RESPONSE TO BAYSIDE COUNCIL - EASTLAKES SHOPPING CENTRE MOD 2

This letter has been prepared by Urbis on behalf of Stateland East Unit Trust (The Applicant) in regard to MP09_0416 Mod 2 – Modification to Eastlakes Shopping Centre Mixed Use Development. The Modification was placed on public exhibition during September and October 2017 and one submission was received from Bayside Council dated 10 October 2017.

DRAWING TITLE
**CONSTRUCTION PLATFORM
VEHICLE TURNING PATH**

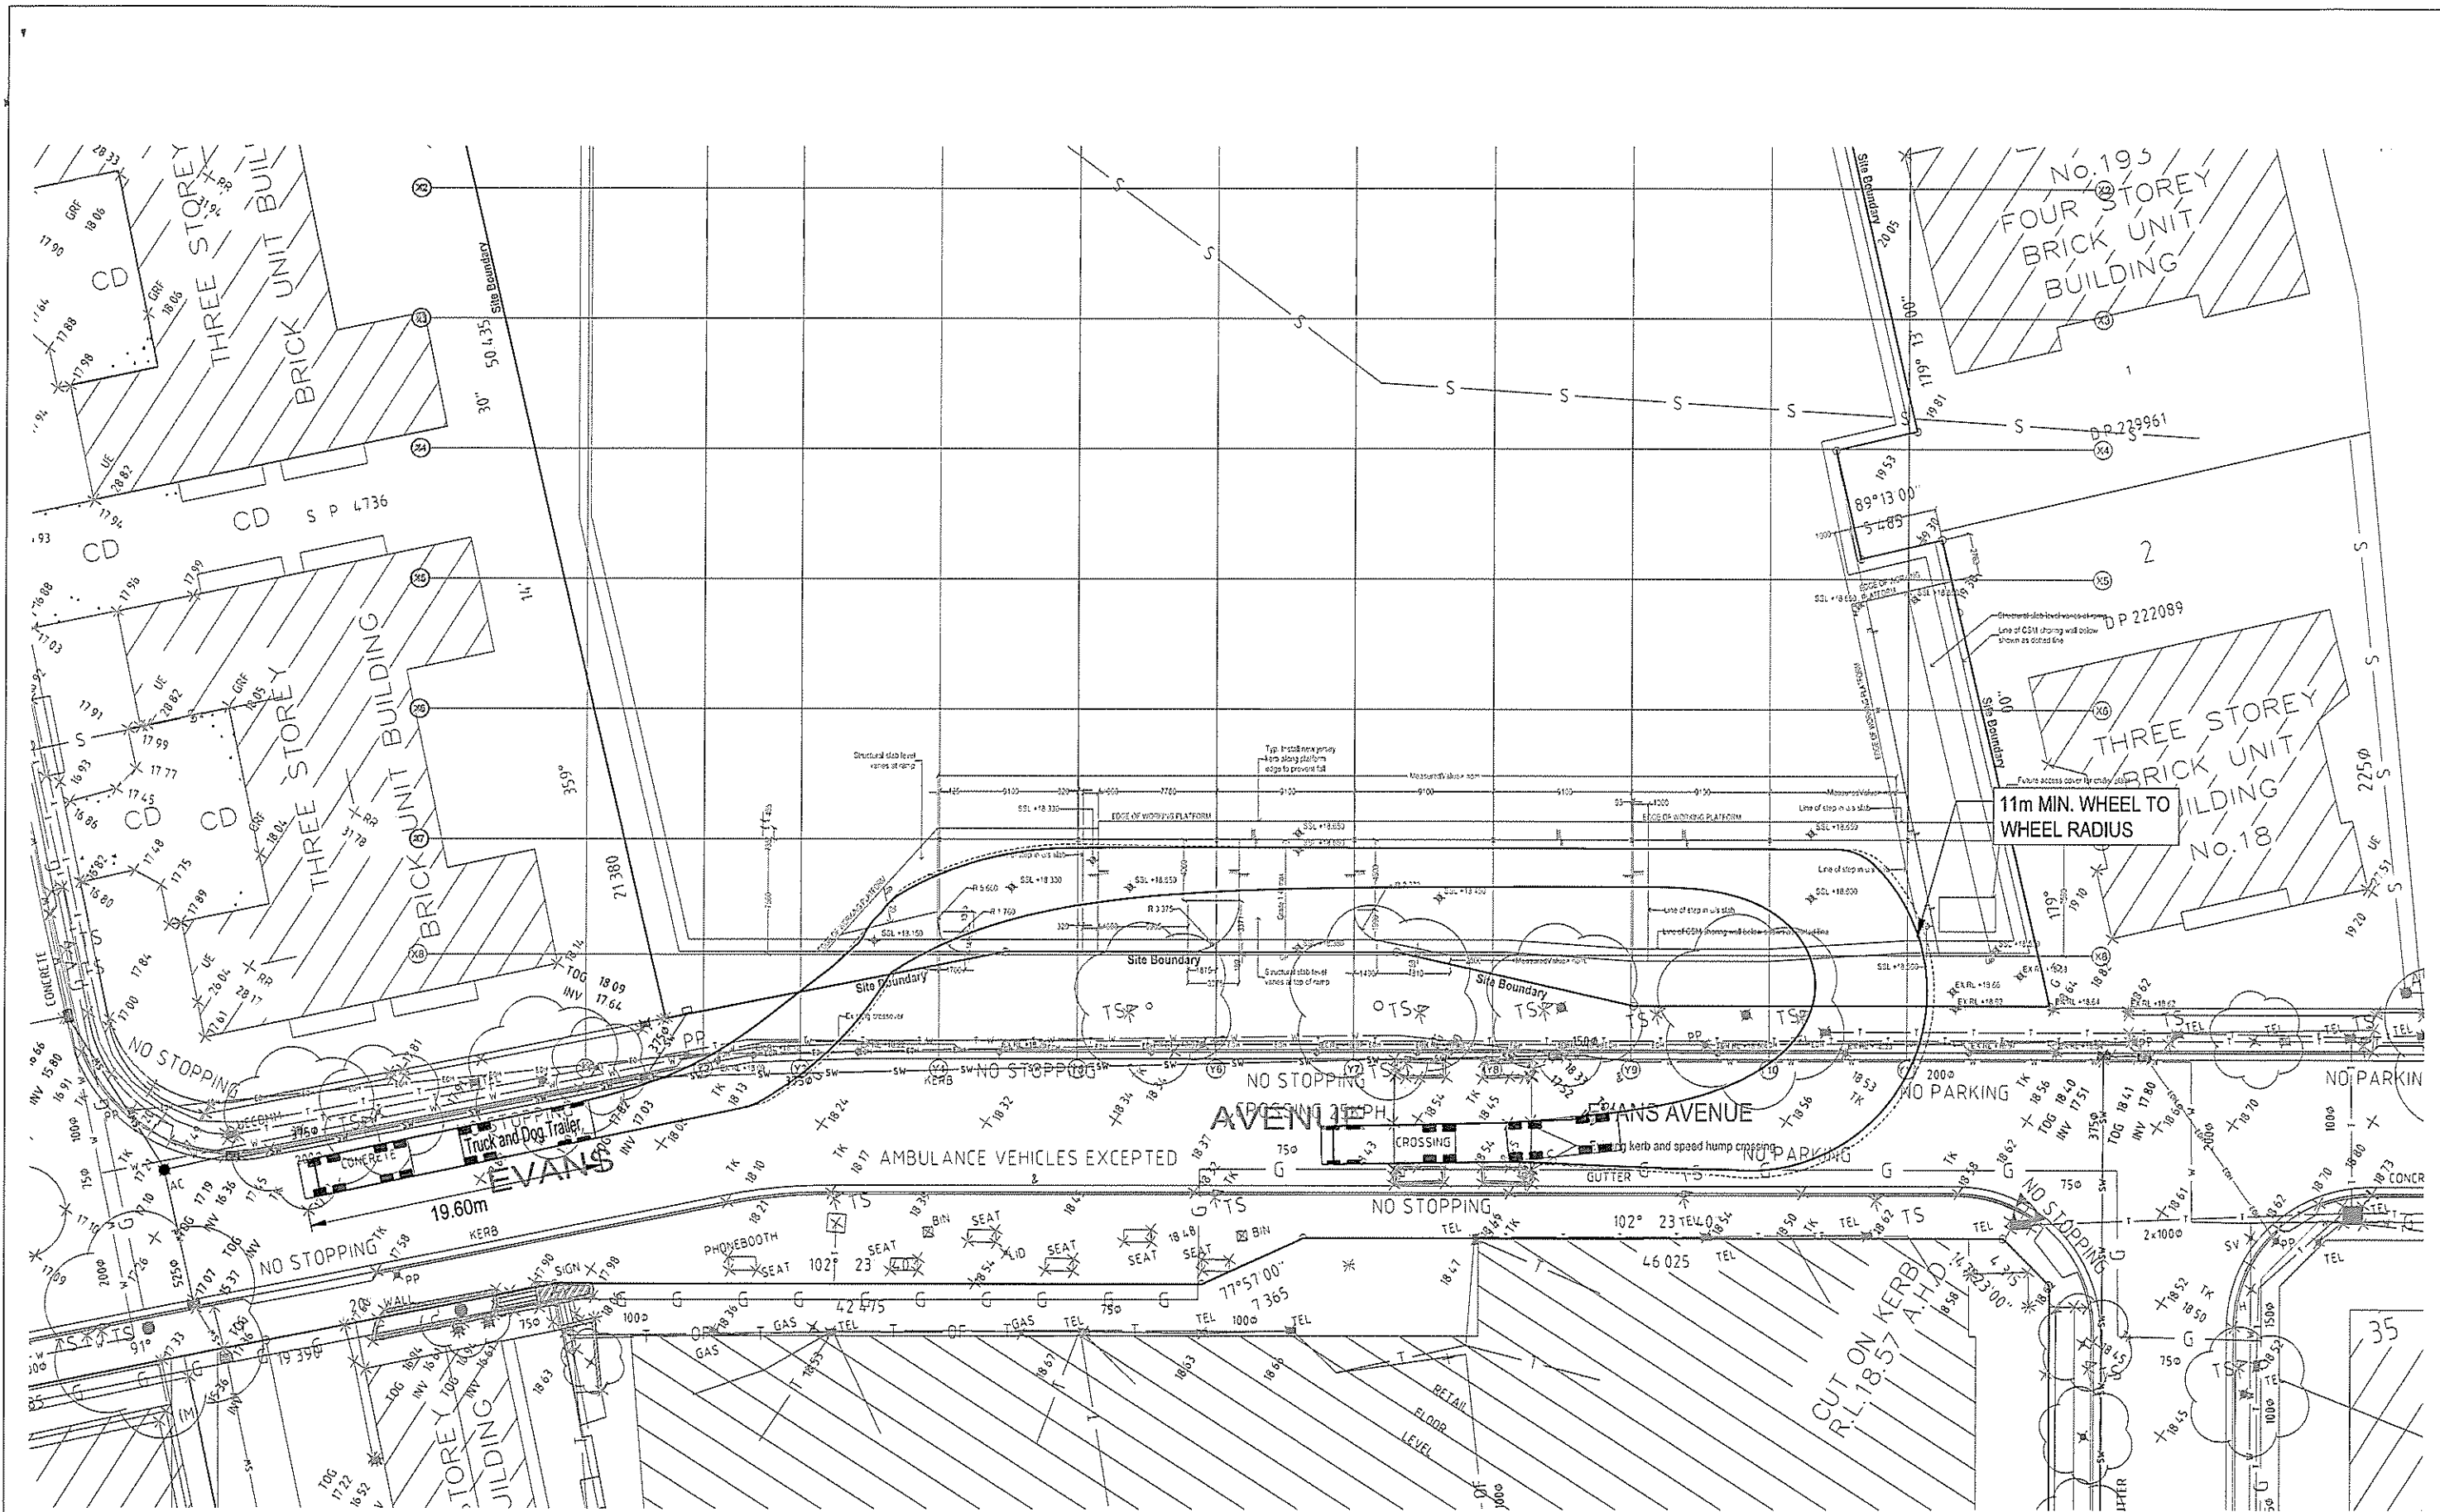
1. *Council also requests that a swept path analysis be provided for the following intersections:*

- *Gardeners Road and Racecourse Drive, Eastlakes and*
- *Racecourse Drive and Evans Drive, Eastlakes*

to ensure the movement of larger trucks can be facilitated through these intersections. Council is aware that 12 metre buses already face difficulties in moving through these intersections and therefore has significant concerns about the practicality of a 19-metre truck completing such a manoeuvre without causing significant traffic issues and potential infrastructure damage.

2. *Council also requests investigation of existing road pavement adequacy to cater for the largest proposed vehicles and design and reconstruction of the road pavement for the travel route identified above, in accordance with Austroads - Guide to Pavement Technology Part 2: Pavement Structural Design, 2012.*

A swept path diagram showing all intersections has been prepared and is attached to this letter. This diagram clearly shows that the 19m truck and trailers would have no problem navigating the route. The Construction Contractor, Christie Civil also notes that truck and trailers are more manoeuvrable than the buses that use the route due to the double articulation in the middle of the vehicle. Further, semi-trailers delivering to the shopping centre regularly use the same route without any issues.

An investigation of the adequacy of the existing road pavement to cater for the proposed change between the 12.5m Truck and the 19m Truck & Trailer has revealed that there would be an approximate 16.0% reduction in vehicle loading as calculated in accordance with Austroads – Guide to Pavement Technology Part 2: Pavement Structural Design, 2012. The design calculations are shown on the swept path diagram attached to this letter.
